Comment	Response
1 Please include file number PA22-017 on all future site, landscape, civil and lighting plan submittals.	File number added to all sheets.
2 As outlined in pre-application comment No. 20, the applicant shall be required to submit a narrative outlining compliance with the applicable site and building design standards outlined in the Lakewood Neighborhood Master Plan, with the formal land use application. This includes demonstration of compliance with the following design standards:	Acknowledged. Point-by-point responses are provided below.

Review Comments By: Brad Zahnow, Development Services Technician

Review Comments Date: April 29, 2022

Response Date: August 1, 2022

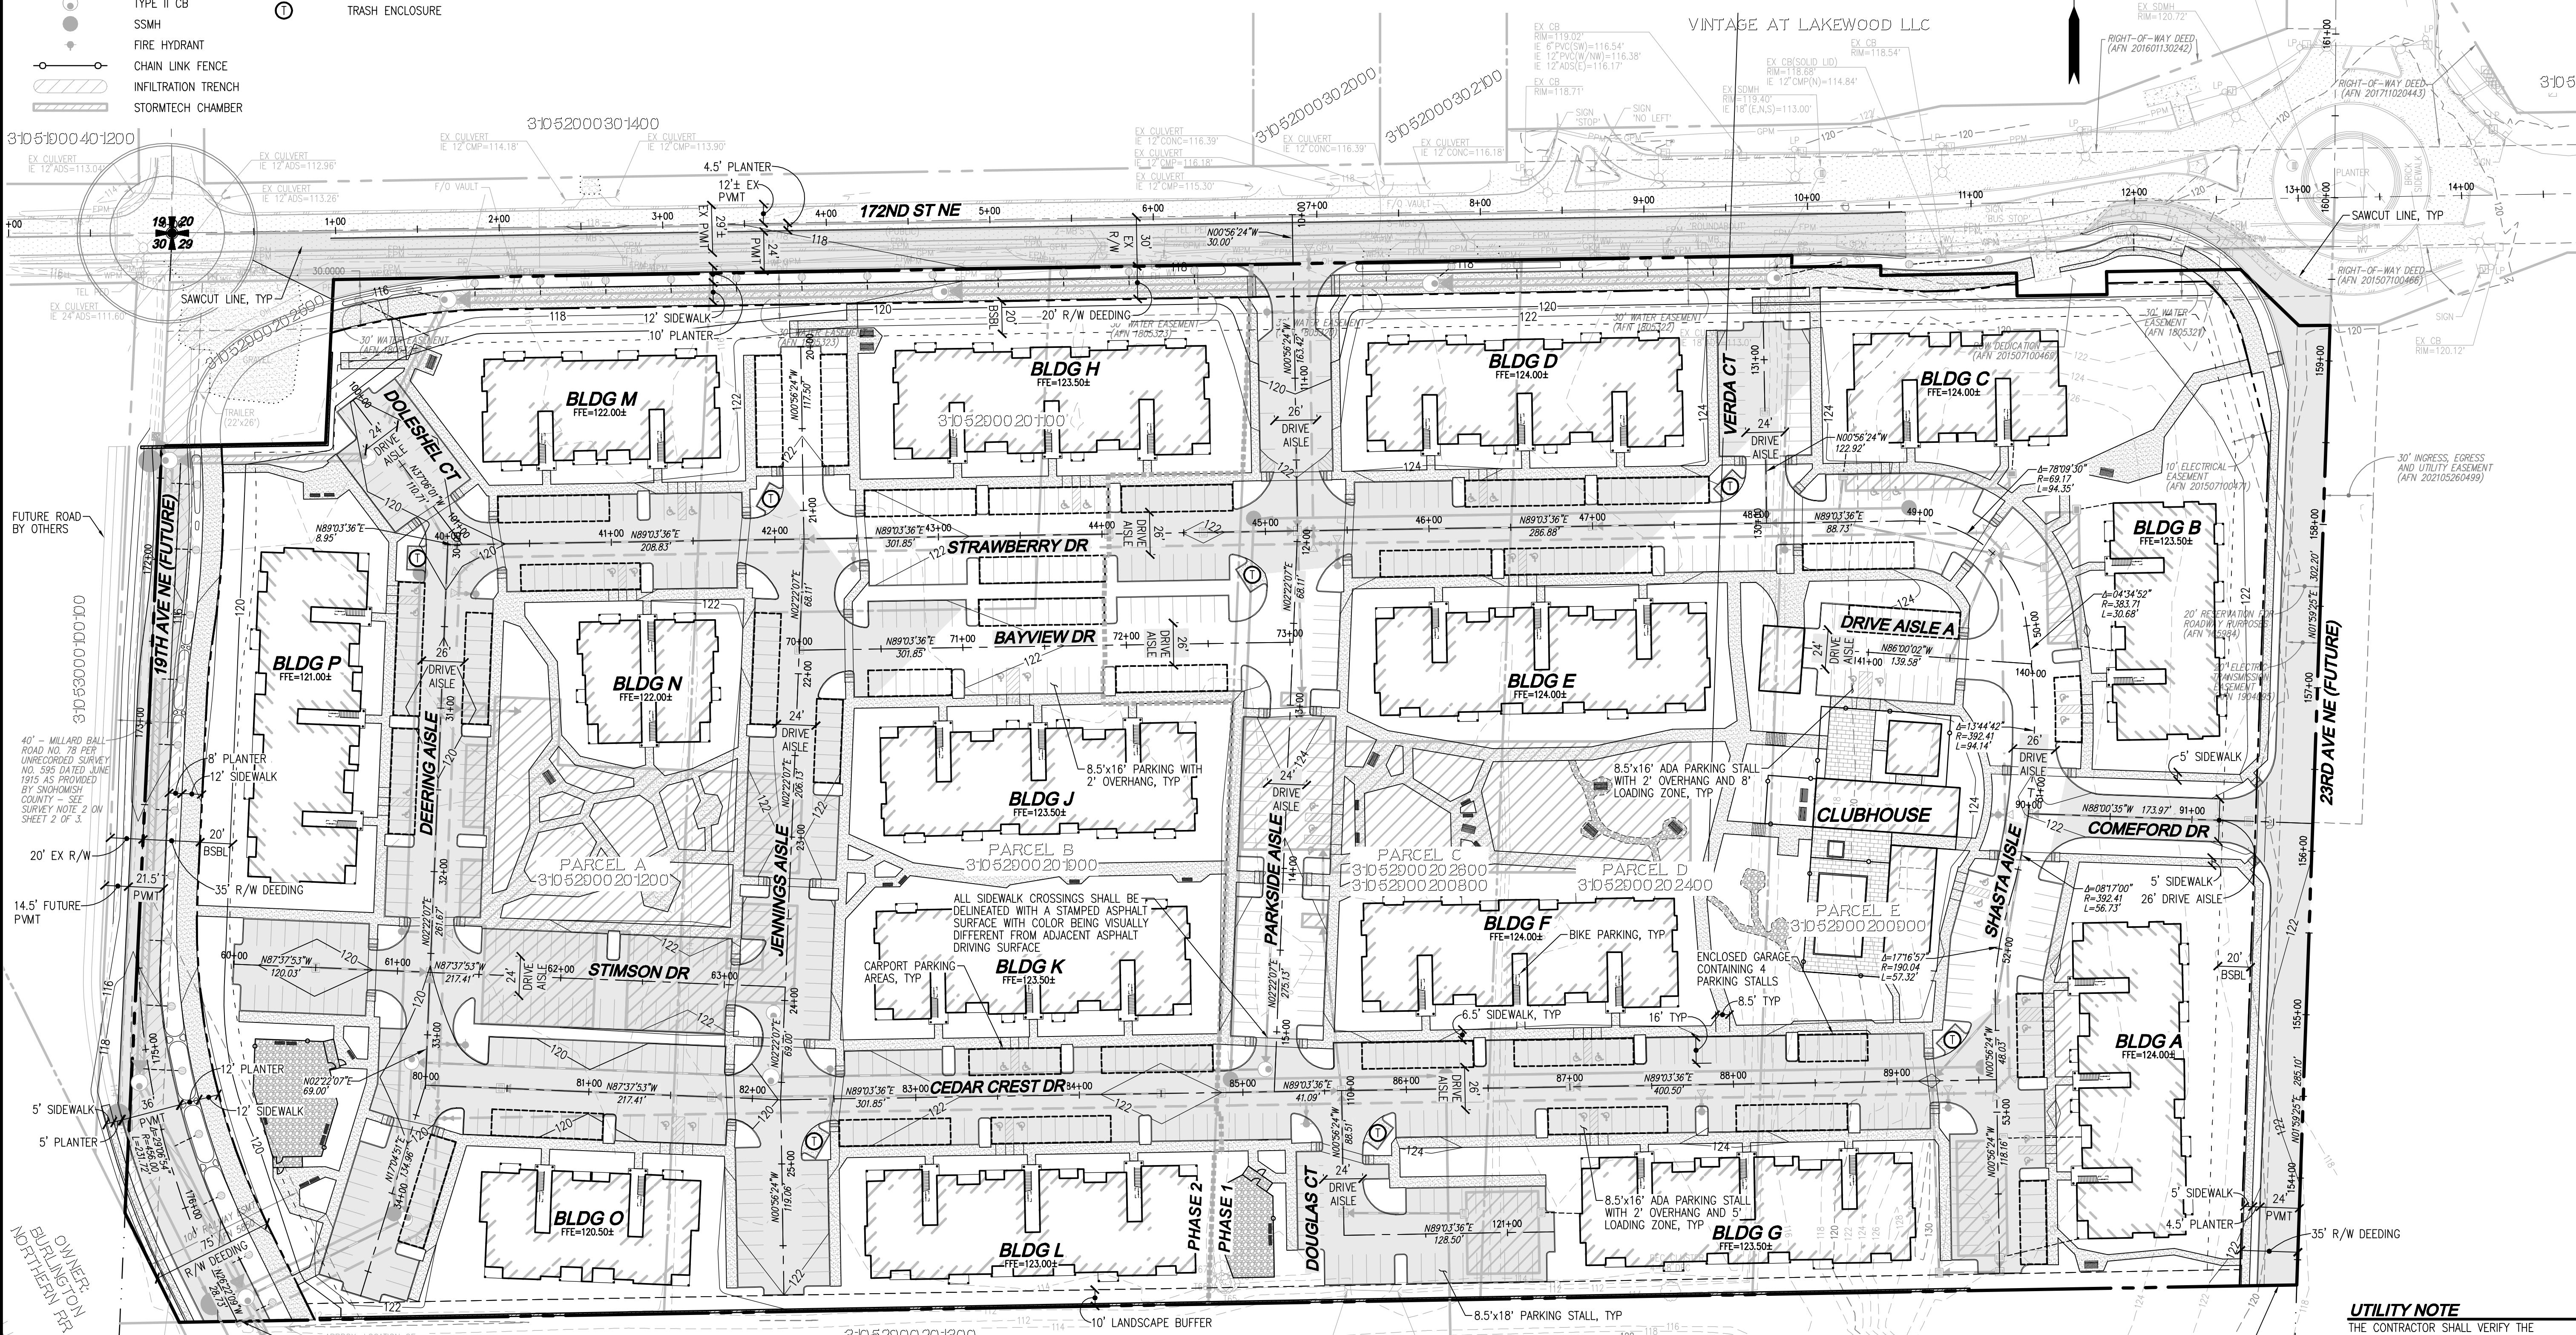
4.2	As referenced on the Civil Plans, the project is to occur in (2) phases. Revise plans to clearly show the dedicated areas of Phase 1 and Phase 2; the existing denotation is difficult to read.	Phasing line weight has been darkened on the Site Plan to better delineate each phase of project. Refer to sheet SP-01.

4.3	Provide the following bulk and dimensional standards:  . Street setback                   20'  . Interior setback                 15'  . Height                               45'  . Impervious surface coverage   75%  It appears that Buildings G & L may encroach into the required setbacks. Encourage a greater setback on the south property line, as a required 10 L1 Landscape buffer is required to be provided, which will likely take away all solar access to Buildings G, L & O.	Buildings G & L have been adjusted to provide a 15' minimum setback from the south property line. Design impervious coverage has been added to the Admin Site plan ASP-02.

4.4	Demonstrate compliance with impervious surface standards (75% maximum). Show calculation and total impervious surface percentages allowed and proposed.	Total impervious area and associated lot coverage calc has been added to the Admin Site Plan ASP-02.
